Recommendation Report for Consent to Display an Advertisement(s)

REF NO: BR/239/14/A

LOCATION: Corner of
West Street/Scott Street
Bognor Regis

PROPOSAL: 1 No illuminated (solar panel) pole mounted board sign.

Proposed Advertisement

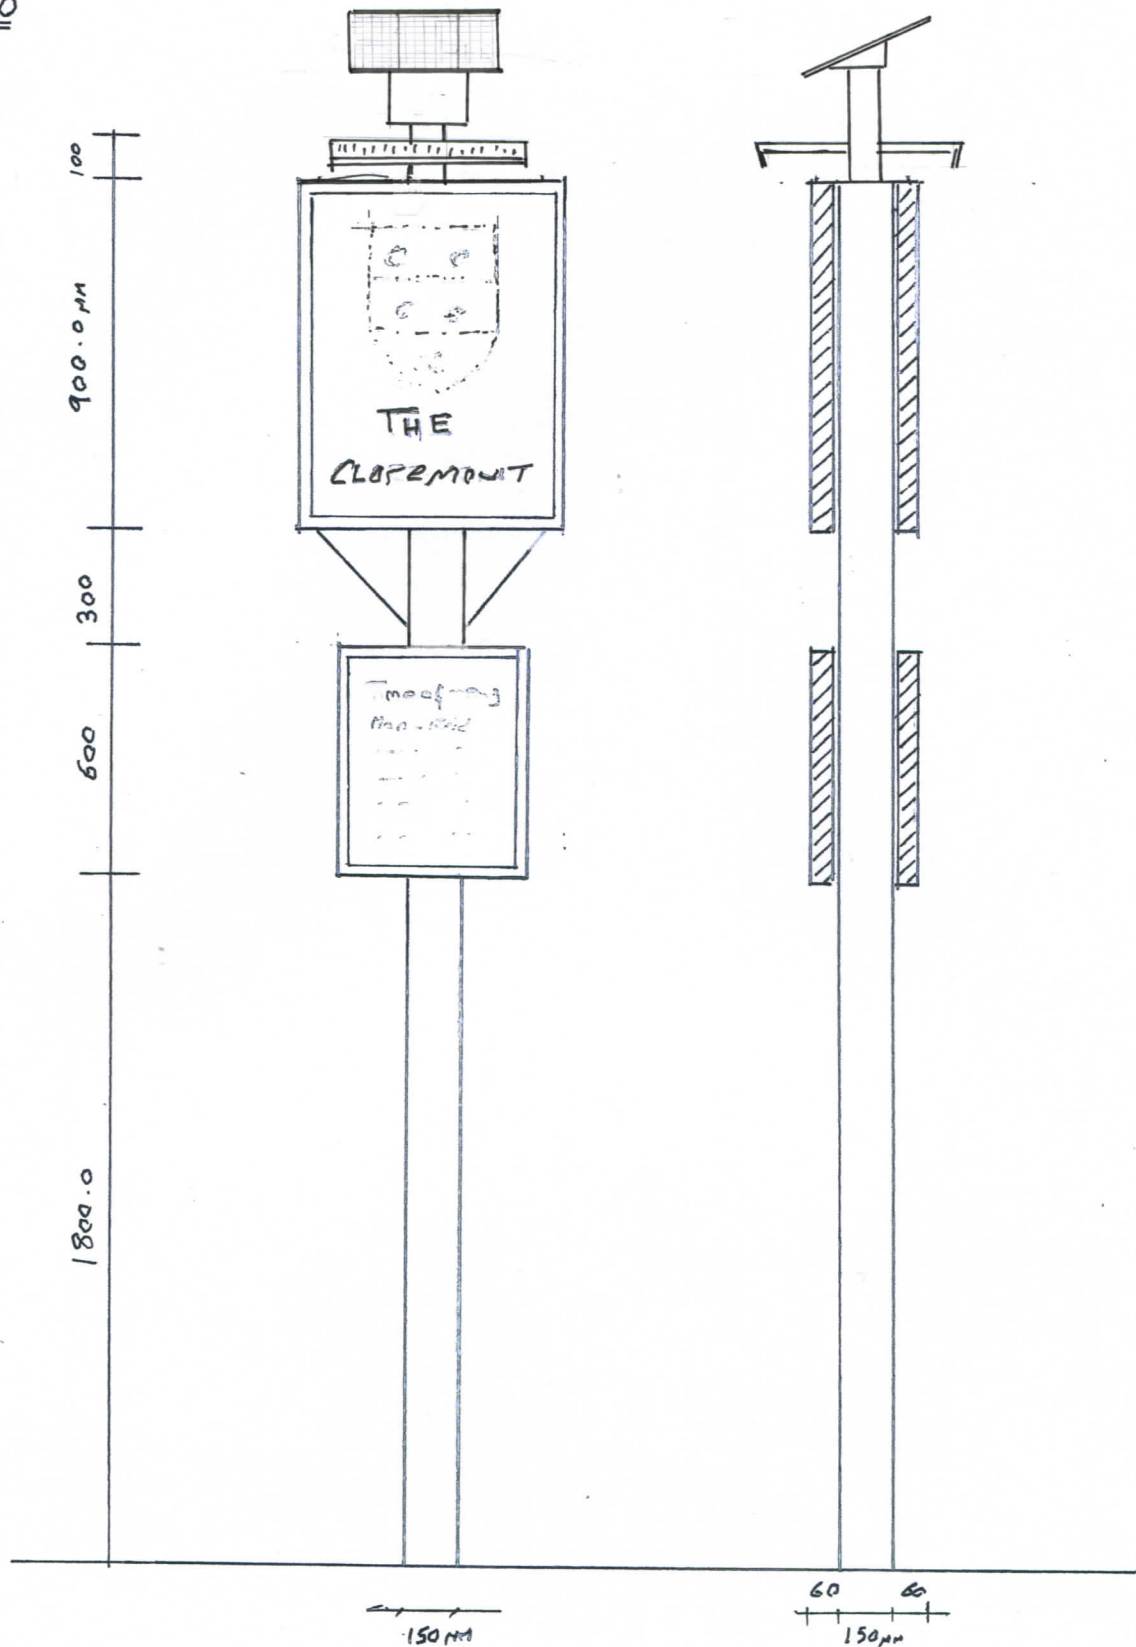
The proposal is for a pole mounted board sign within the Steyne and Waterloo Square Conservation Area. The location of the sign within the pavement at a section of the conservation area where a number of roads diverge is considered problematic. It is considered that the sign is not only complex with the introduction of the solar panels, it would add to the street furniture in the locality, and is of a size that it would be incongruous in the street scene.

The pole sign will advertise the presence of The Claremont Public House which is sited in Scott Street. The pole sign is approximately 2.7m in height and the solar panel will be sited on the top of the pole sign illuminating the board below. The sign is sited on the pedestrian walkway which is within the public highway.

The proposed sign by reason of its siting, height and proposed illumination is considered to be prejudicial to the visual amenities and detrimental to the character and appearance of the Conservation Area.

- 1 The proposed sign by reason of its siting, size & design would be prejudicial to the visual amenities of the locality and adversely affect public amenity in the designated Steyne and Waterloo Square Conservation Area in conflict with Paragraph 67 of the National Planning Policy Framework.

Block Plan
Scale 1:500

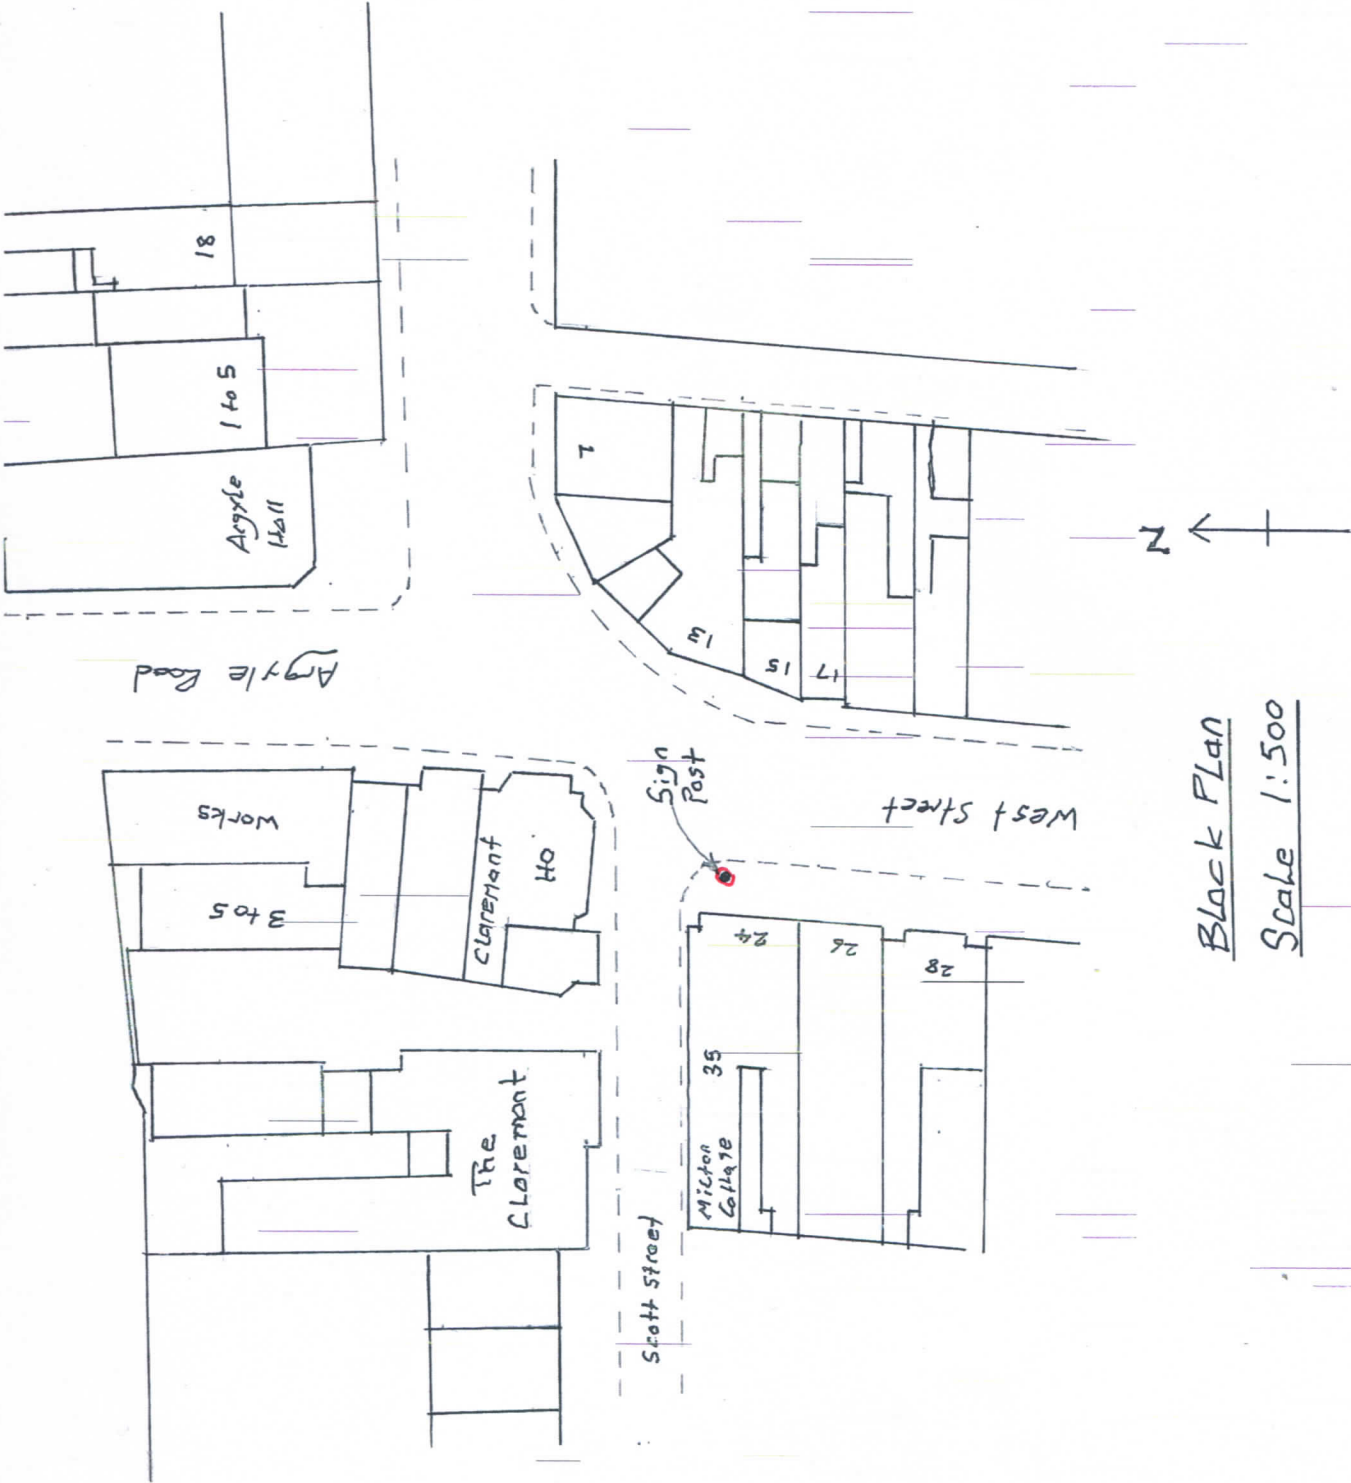
The application seeks approval for the erection of an illuminated pole mounted board sign on the footway next to the junction of Scott Street and West Street. According to current records held at WSCC, this sign is proposed within the public highway. The Highway Authority, therefore, would not be in a position to support this proposal. In order to overcome this reason for objection, I would recommend that the applicant reposition the sign outside the public highway and away from a position that would impede on vehicular visibility.

- 2 INFORMATIVE: The proposed siting of the sign being on the public highway will require the consent of West Sussex County Council who are the highway authority. In this location the highway authority would not be able to support this proposal and they recommend that the applicant reposition the sign outside the public highway and away from a position that would impeded on vehicular visibility.
